2023/1001

9 Stevenson Drive, Higham, Barnsley, S75 1PA

Re-modernisation of existing bungalow including:

1. Raising of roof to provide first floor accommodation
  2. Side extension works to provide larger additional accommodation
  3. Garage extension
  4. Extensive internal alterations and new window and door alterations
-

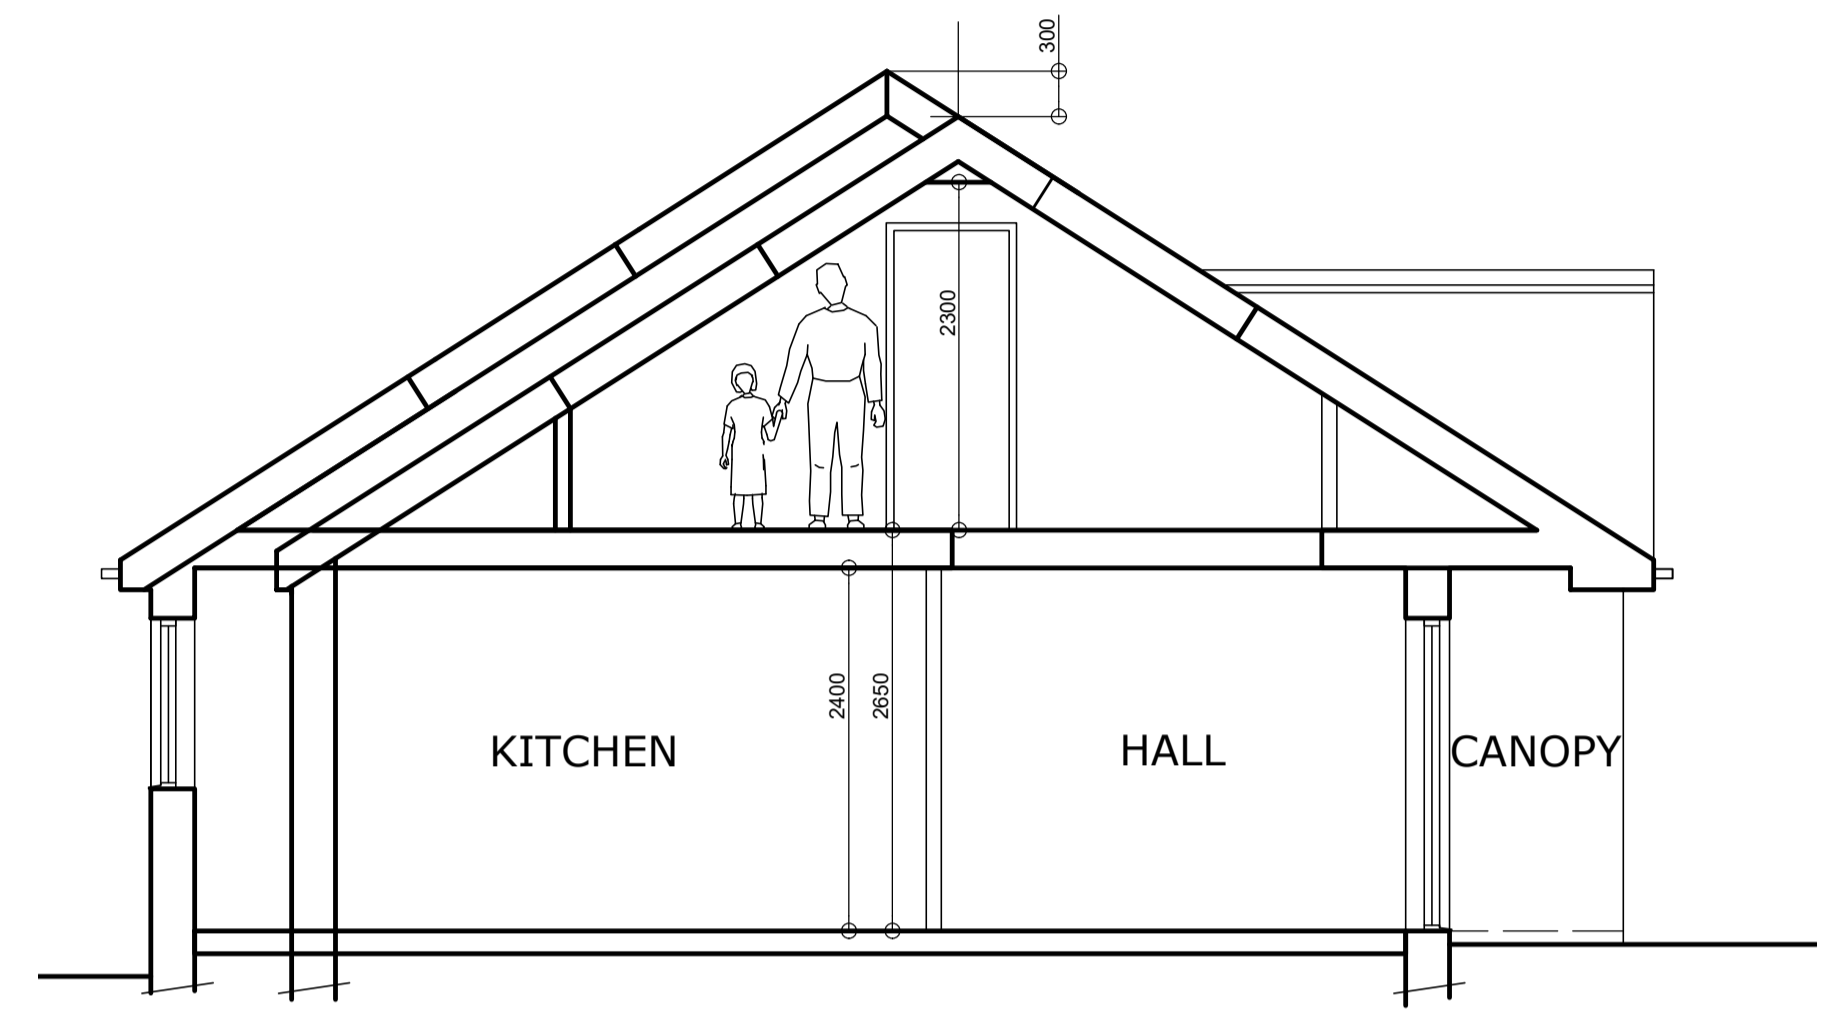
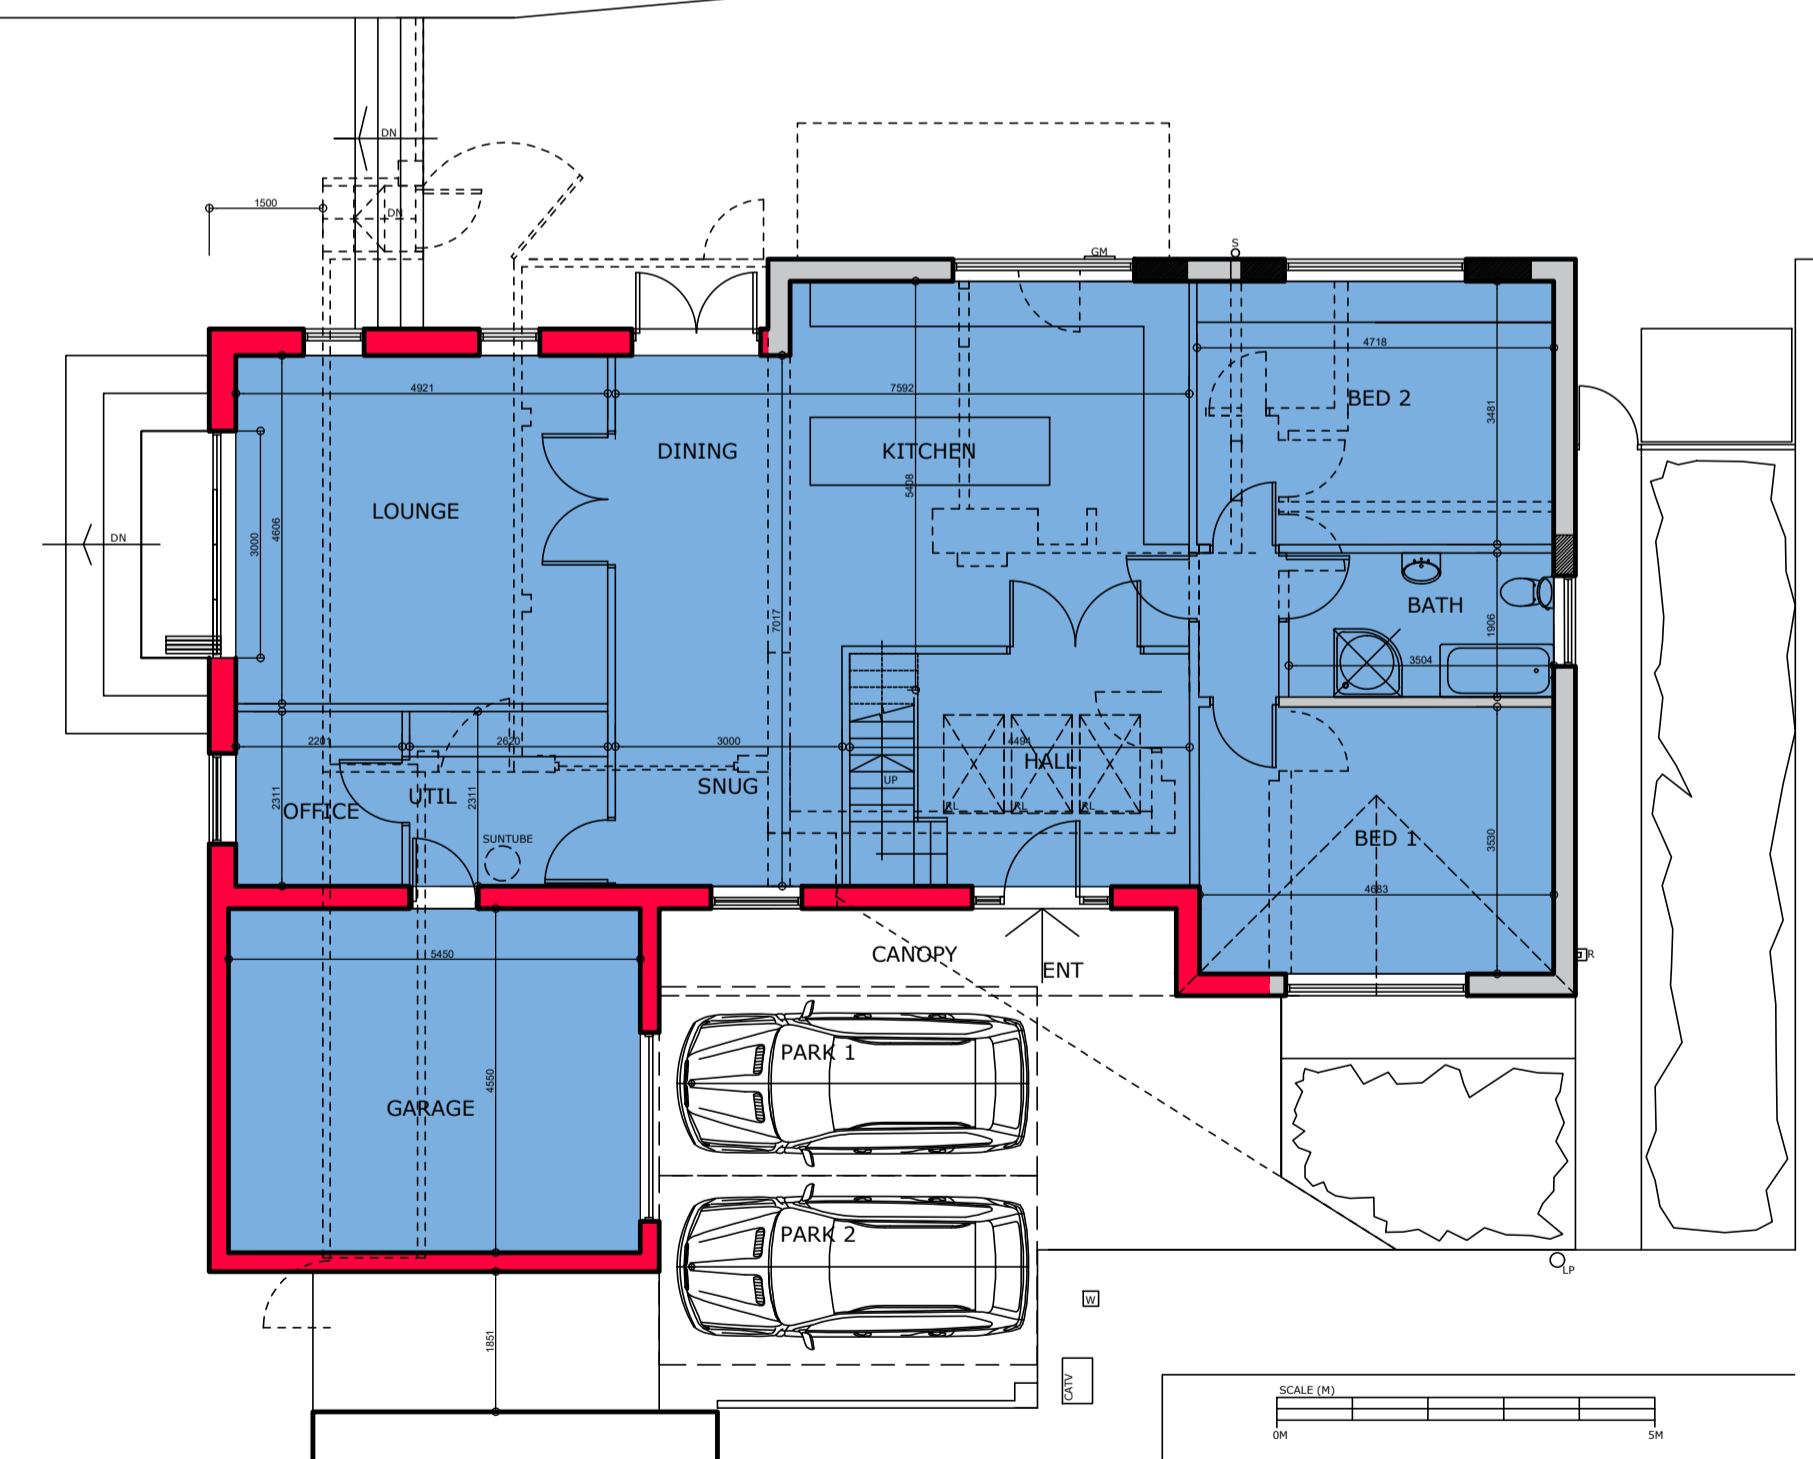
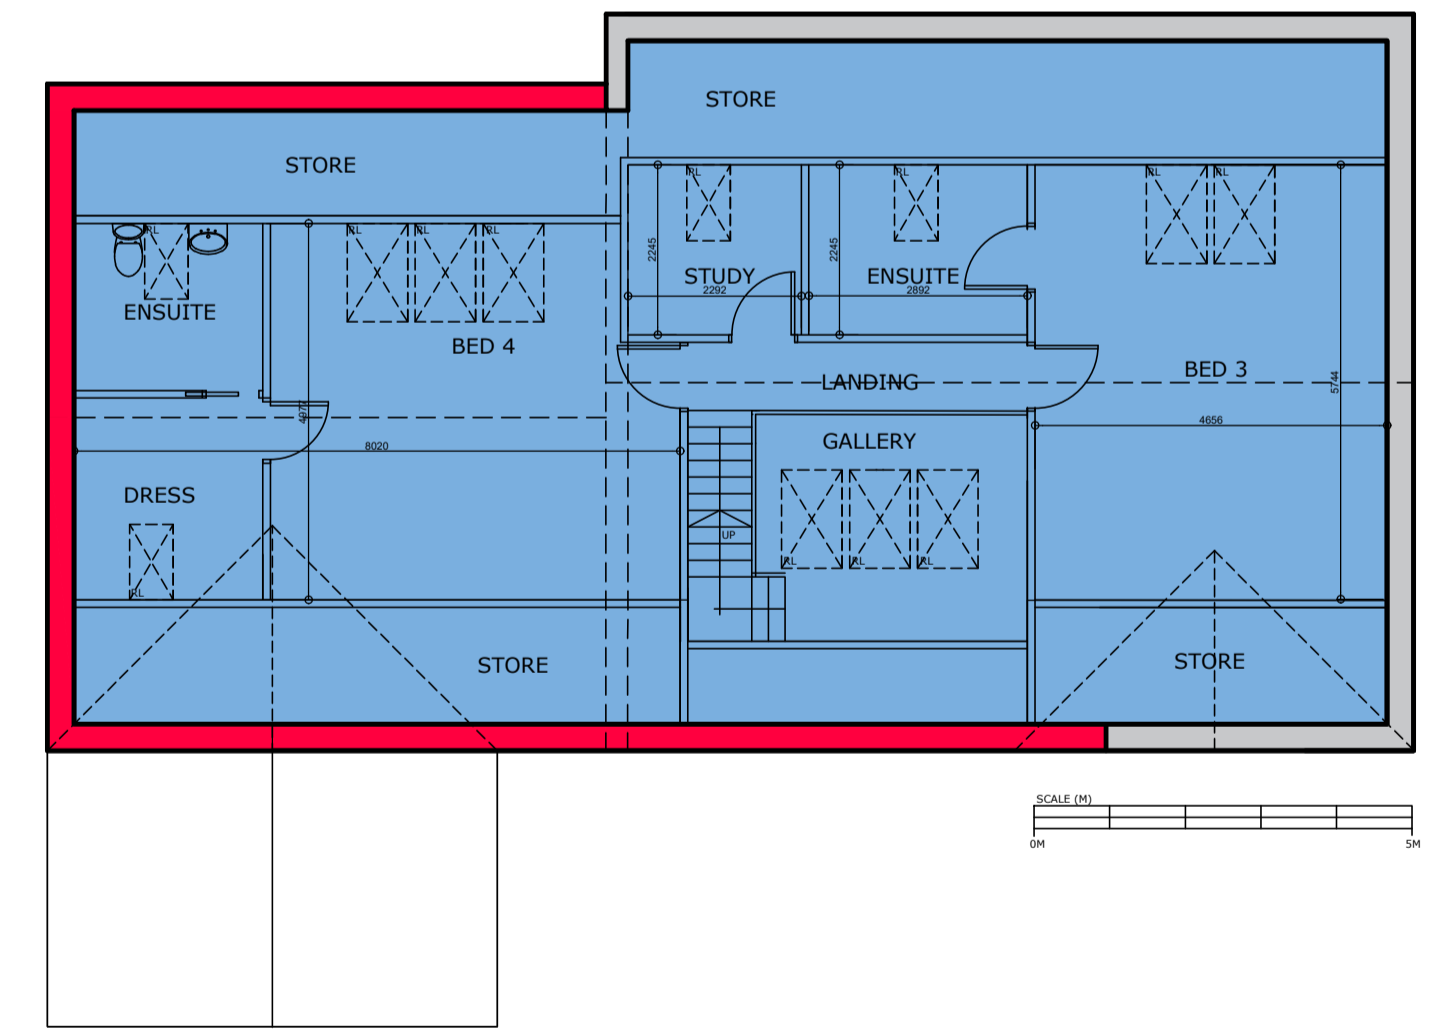
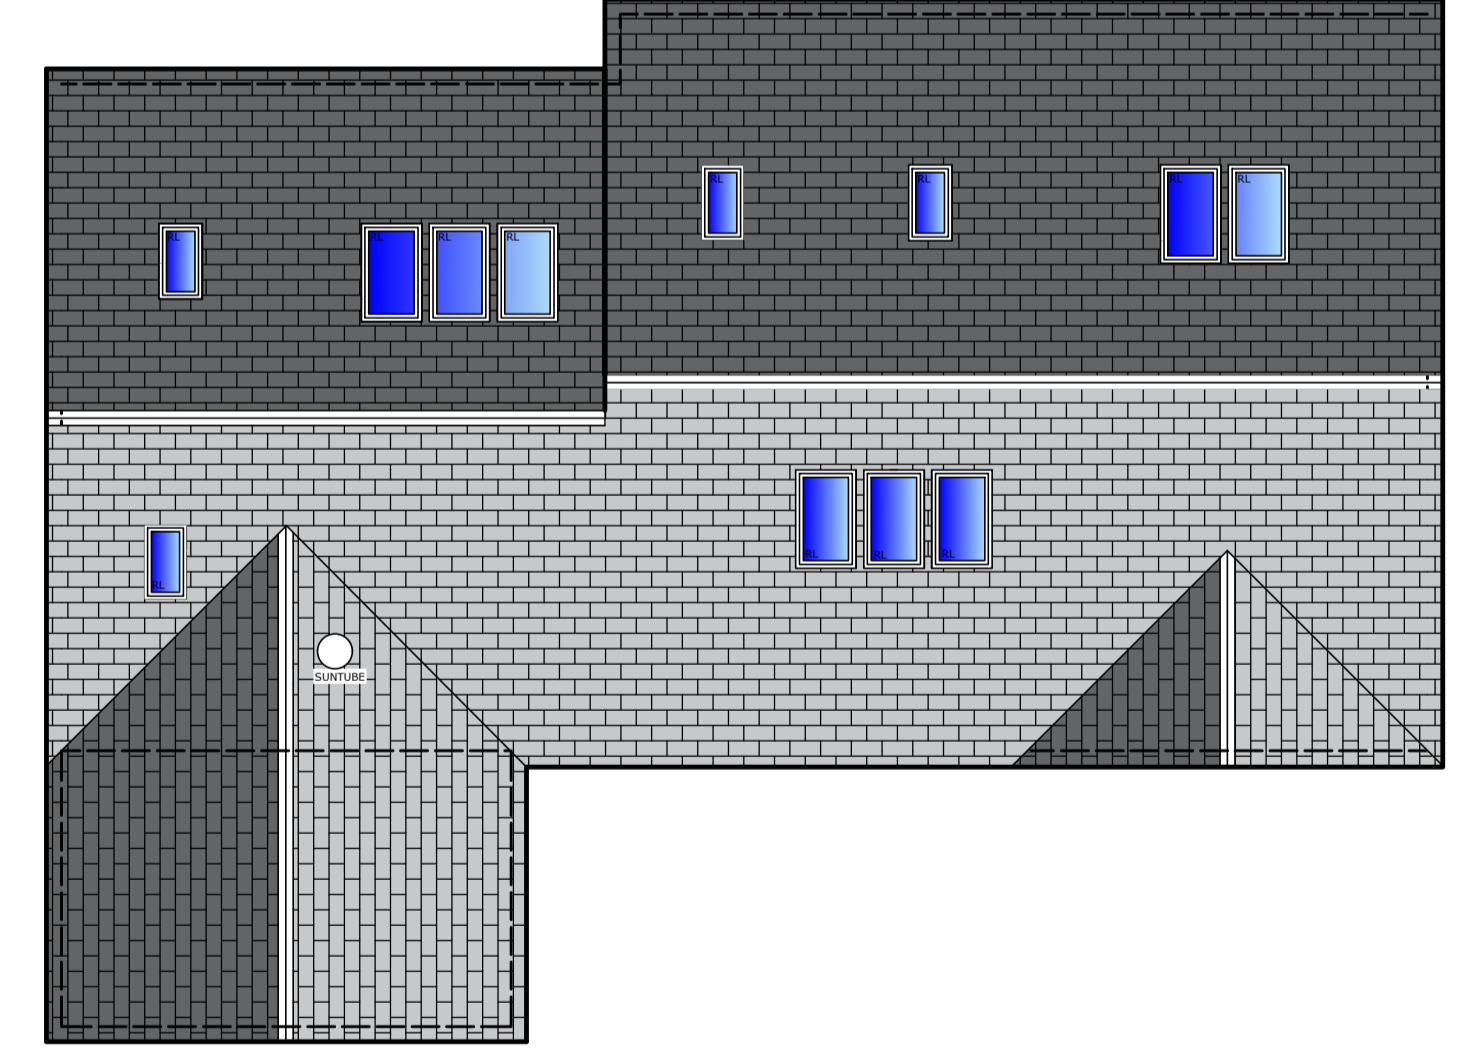
The proposed enlargement and alterations to the external appearance of the host dwelling could impact the character of the street scene. Concerns were raised regarding the proposed increase in roof height and the loss of an existing gable element to the front. It was considered that the proposal would have contributed to an unbalanced and overly dominant appearance. However, amendments have since been submitted to include a reduction in roof height, the re-introduction of gable elements to the front and a step down in the ridge line above the extension. The amended proposal is subject to consideration.

The host dwelling has a greater prominence within the street scene due to its location and positioning within the building line. It is acknowledged that the proposal could exacerbate this. However, it is not considered that any potential harm would be significantly detrimental to the character of the street scene as an overly dominant and overbearing appearance would likely be avoided. The proposal would maintain the existing eaves height and adopt a reduced increase in ridge height. A set down in the ridge line above the extension and a set back from the rear elevation of the dwelling would be provided and gable elements to the front would be re-introduced. Although a greater set down and a set back from the front elevation of the dwelling would have been preferred, the amendments proposed would provide a clear break within the expanse of the roof and would maintain a degree of consistency and symmetry with surrounding properties. Some of the existing character of the original dwelling would also be retained. Additionally, the proposed extension to the north side of the dwelling would not adopt an excessive sideways projection more than two thirds the width of the original dwelling, in accordance with the SPD.
